Application No: FG/54/22/PL
Site Address: Land rear of 1 Sea Drive Ferring BN12 5HD
Description of works: 1 No new dwelling. This application is in CIL Zone 4 and is CIL Liable as new dwelling.

Thank you for your internet representation made on 28th April 2022 which has been recorded as an objection with the comments as follows:

Proposed Site Plan  
Scale 1:100 @ A1

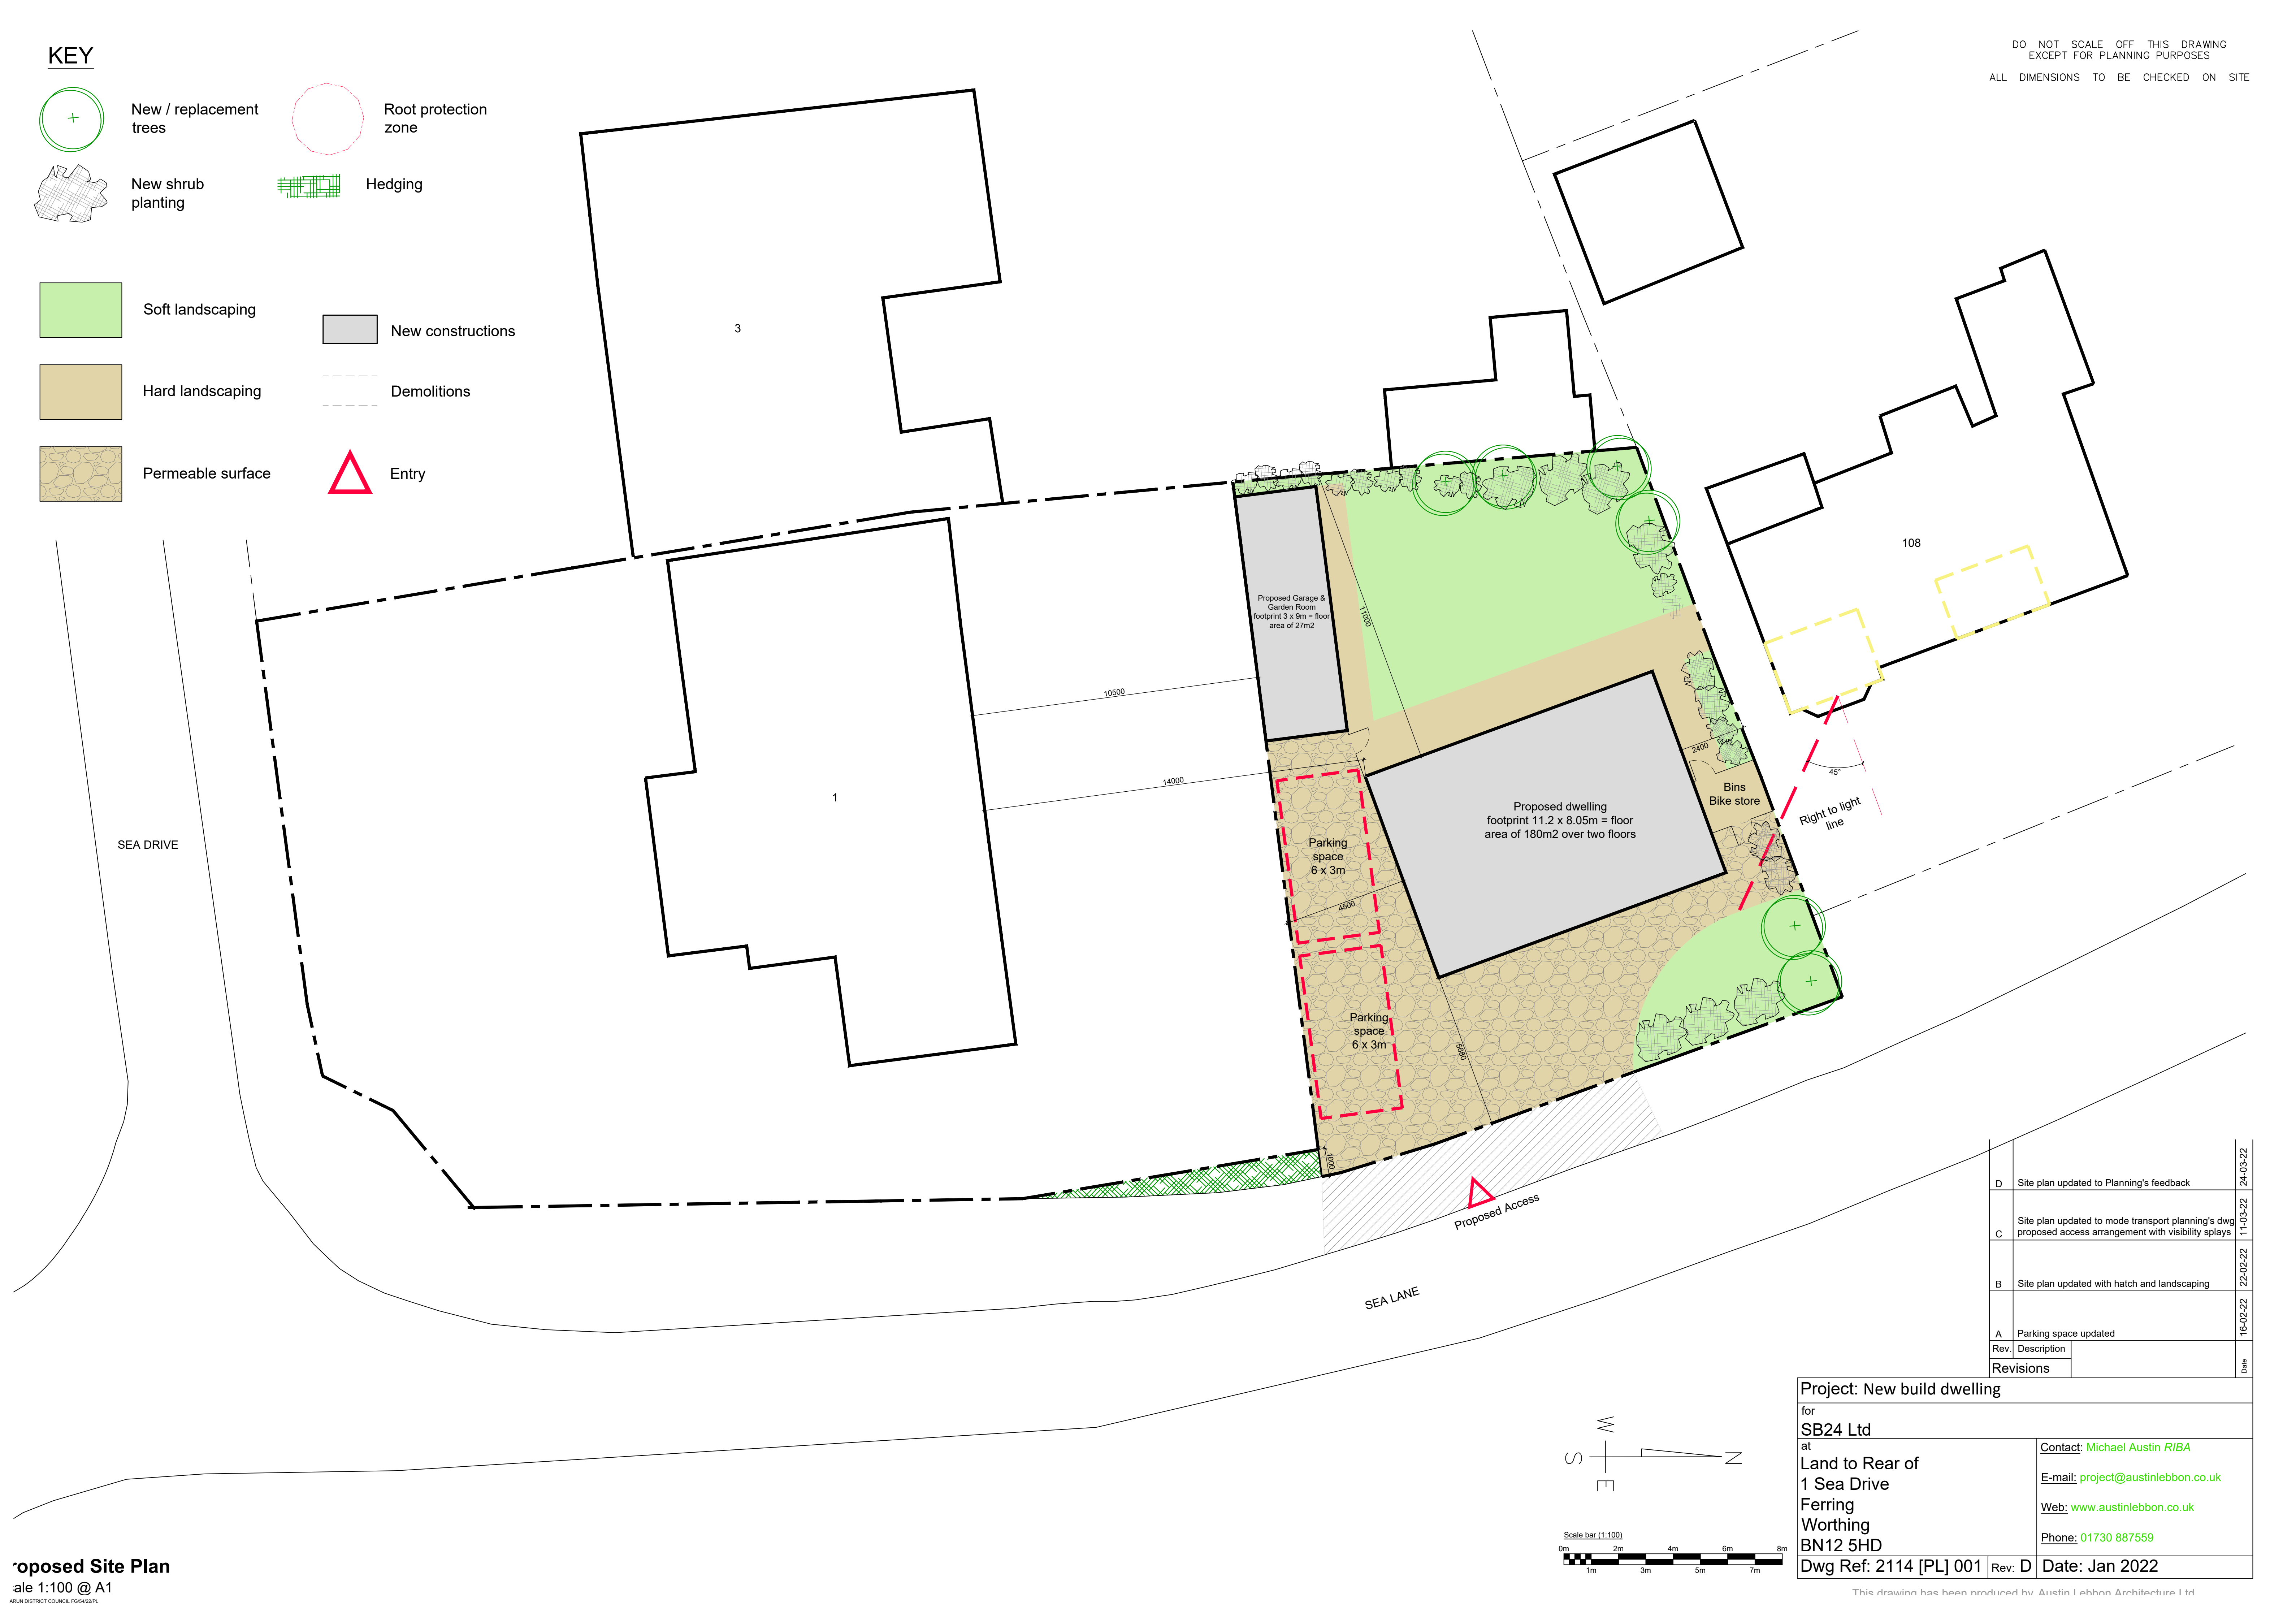
The proposed car parking arrangement will result in vehicles reversing in or out of the site. This being situated very close to the junction of Sea Lane and Sea Drive at the sharp bend in the former will present potential danger to vehicles using Sea lane
